3.4 CHILD CARE

3.5 BUILDING HEIGHT

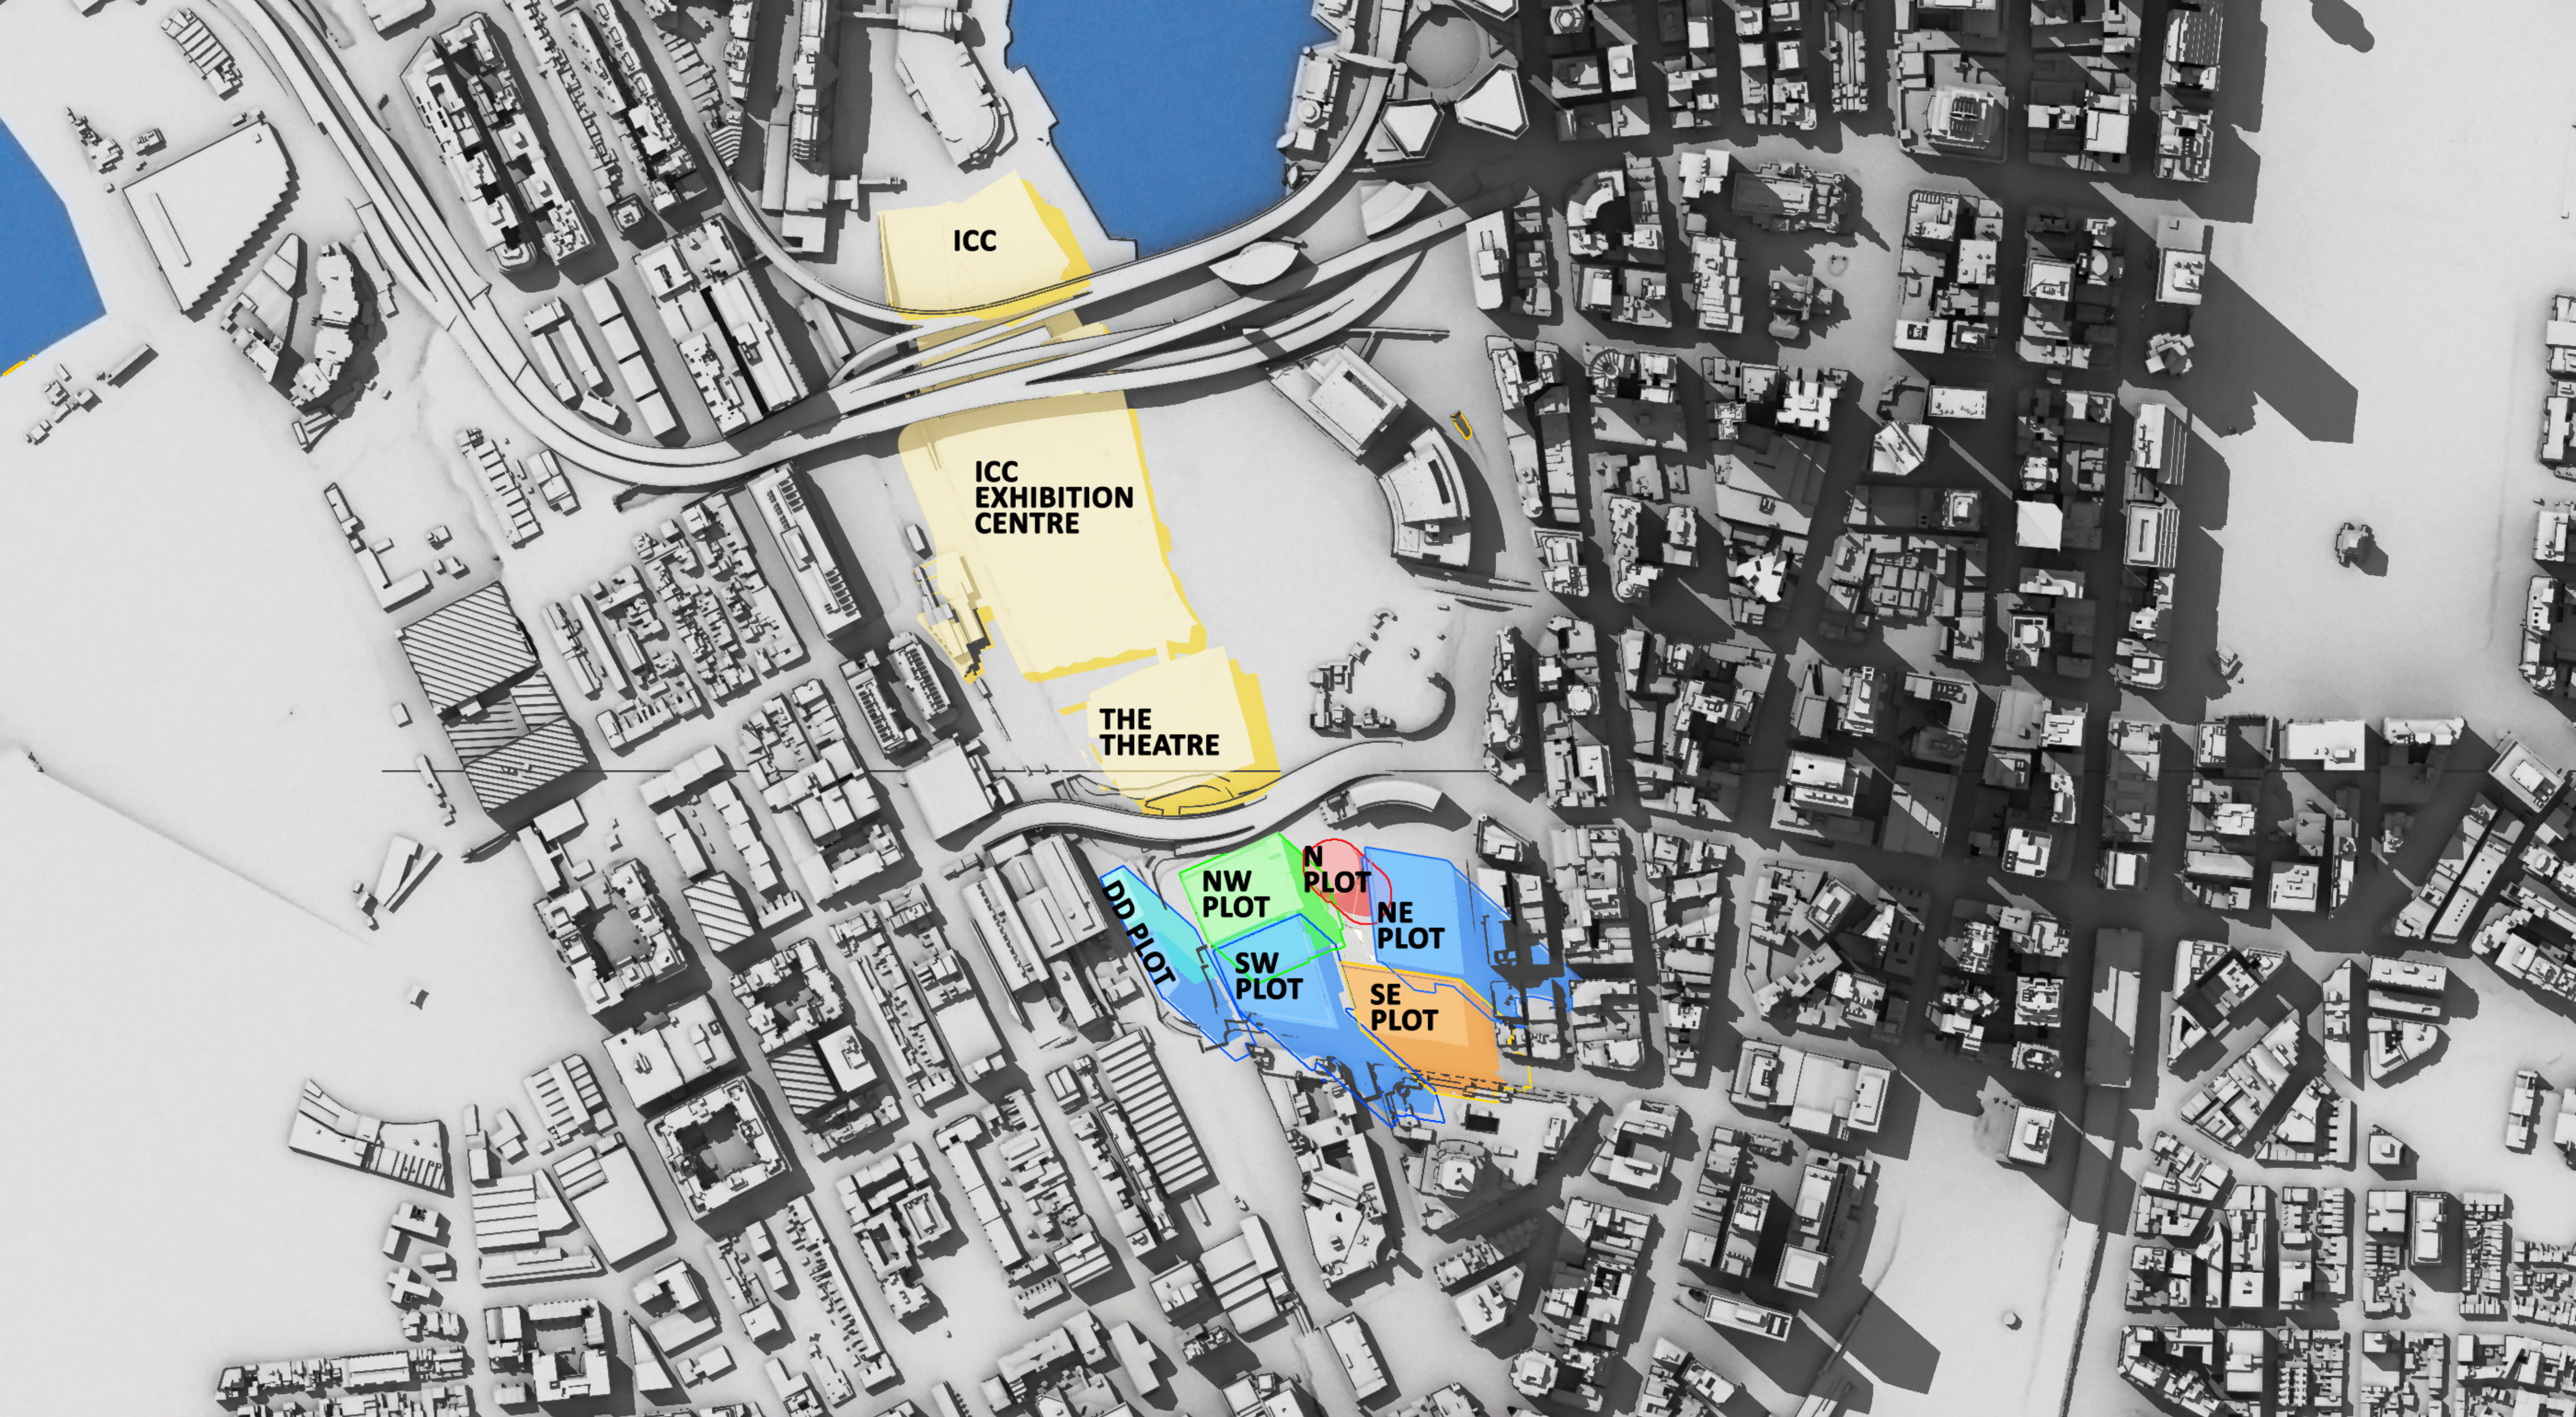
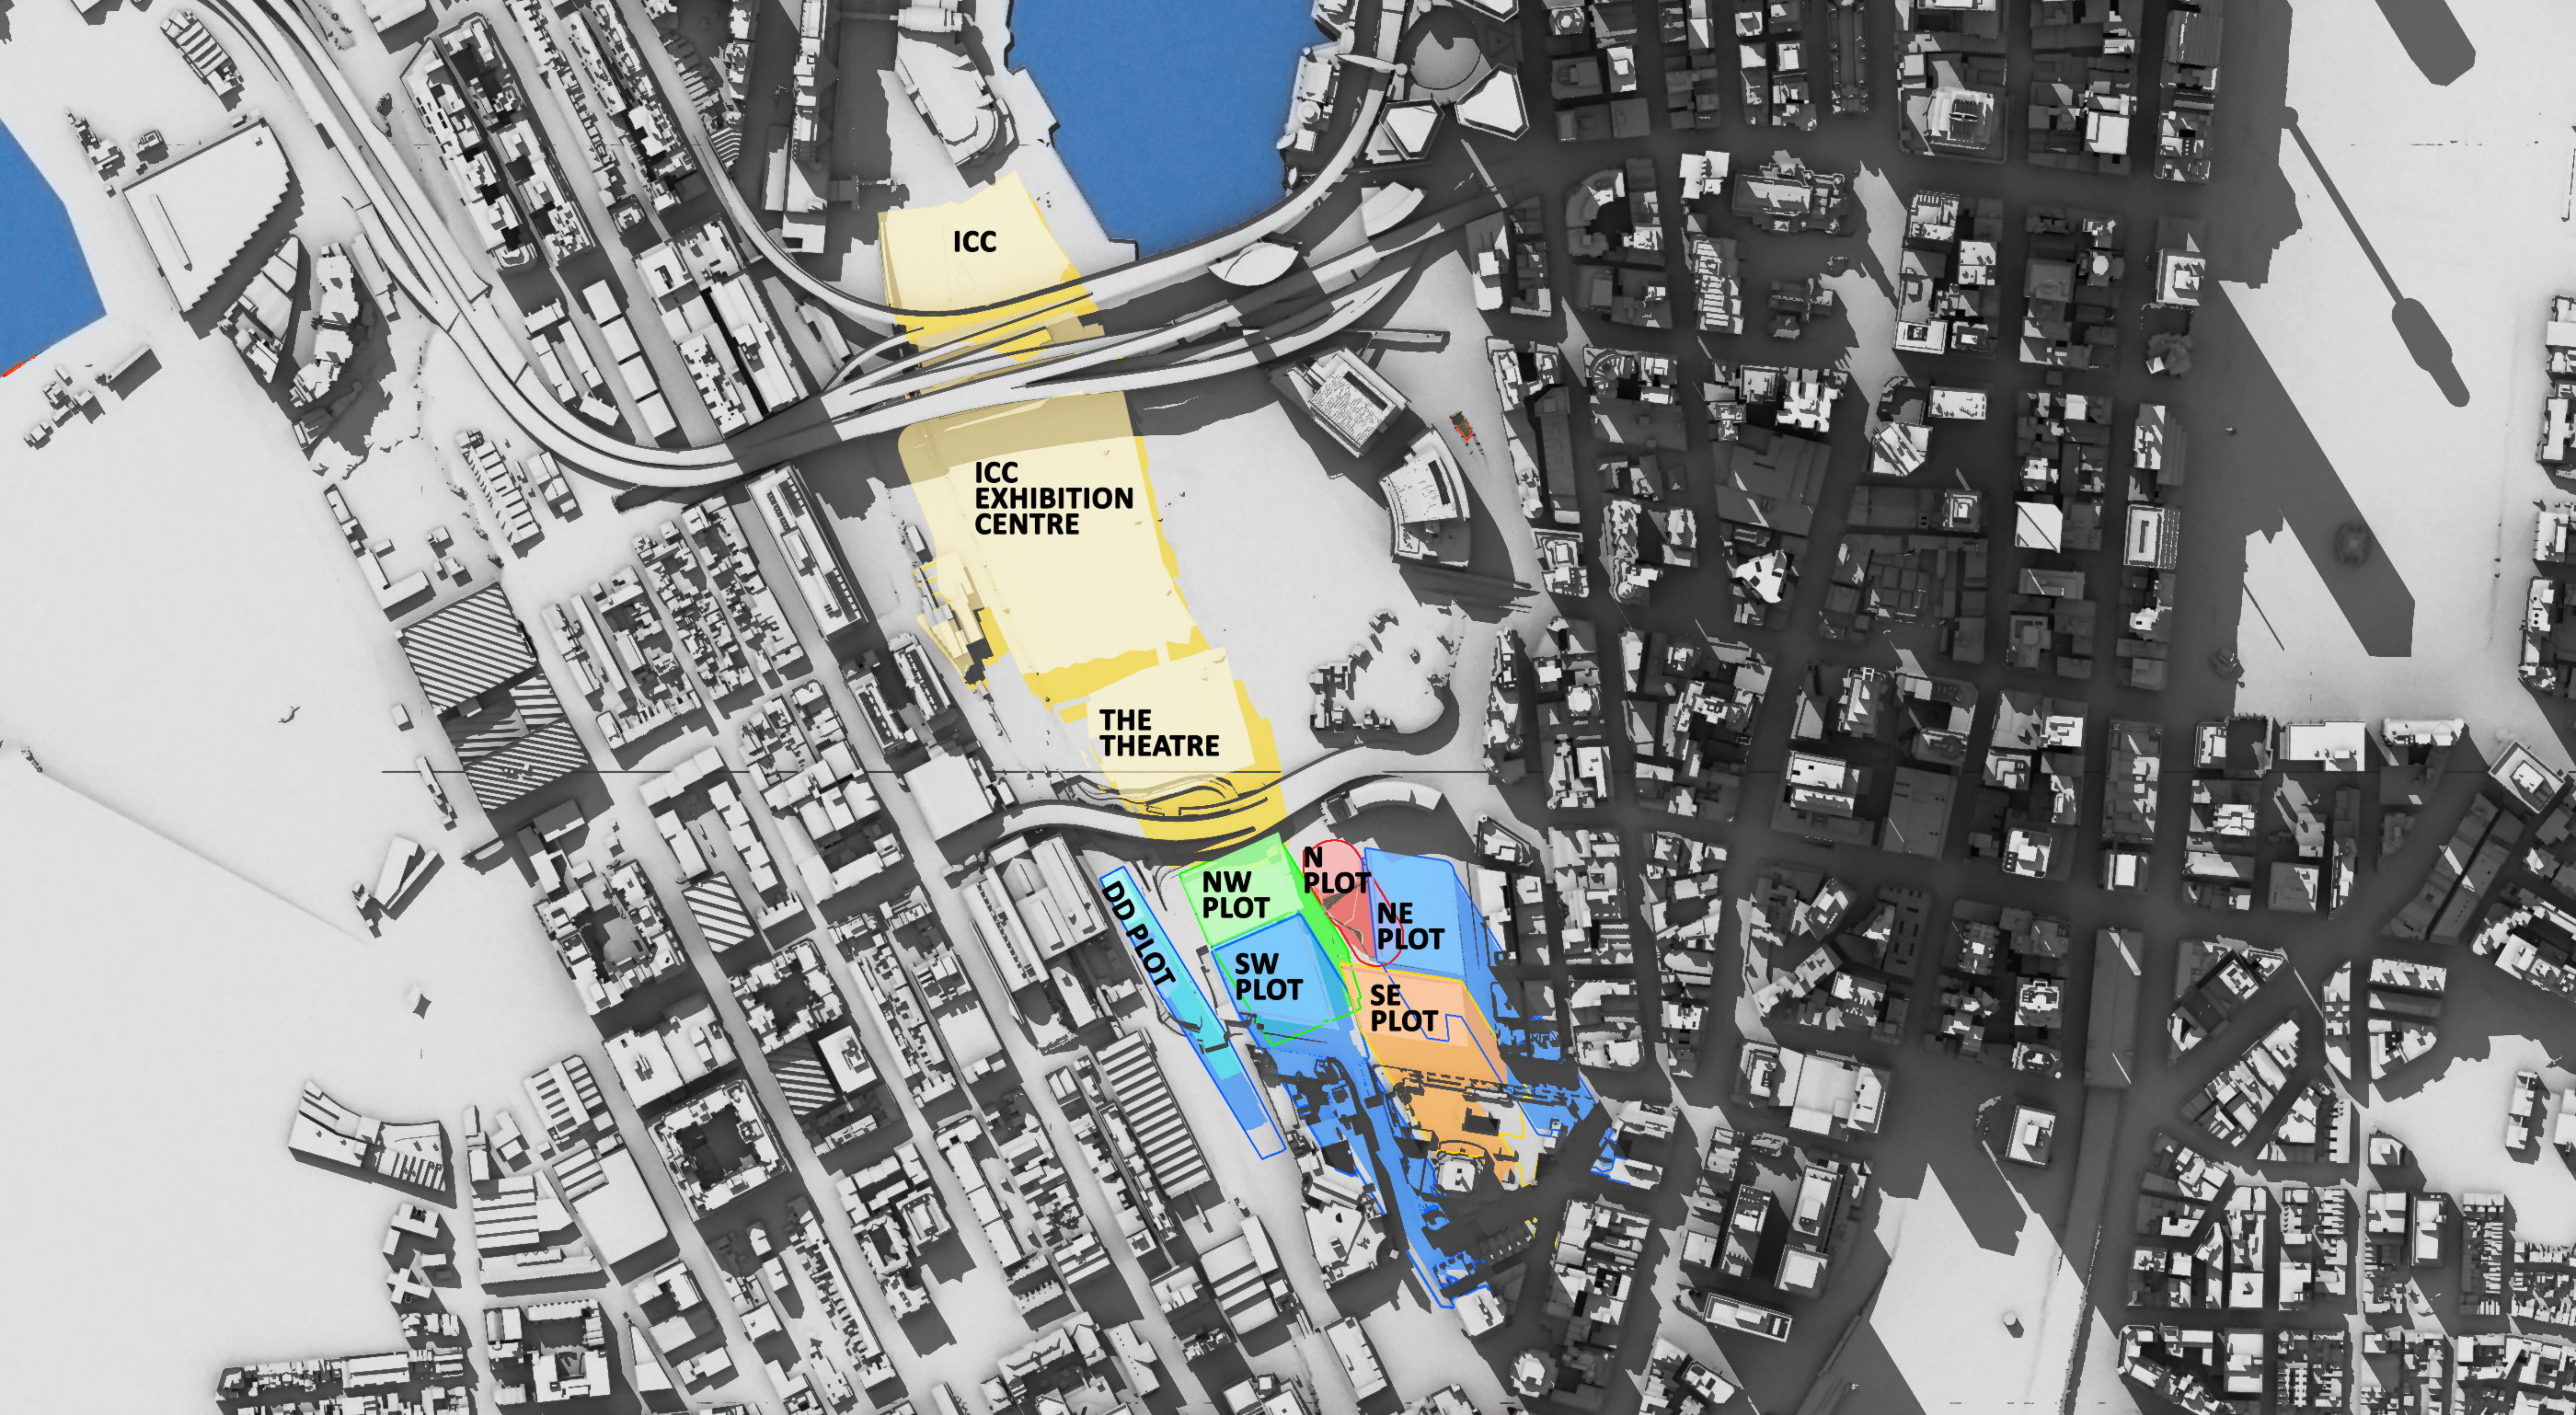
The Authority notes that the height of the proposed building (Darling Exchange) on the North Plot has increased by 5 metres. Any increase in building height should not create additional overshadowing across Haymarket Square during mid-winter. Further modelling is considered necessary in order to ensure solar access across Haymarket Square is maximised, especially the critical 12 midday to 2.00pm lunch time period during mid-winter and to confirm that the built form of the Darling Exchange does not dominate the public square.

The impact from the 5m increase in height has been assessed in great detail as part of the S96 modification to the Concept Plan which has now been approved. The building is entirely within this parameter plan and consistent with the overall parameter plan height control.

The building has been positioned to minimise the shadowing throughout the year. Refer to Appendix B - Shadow Analysis for further information.
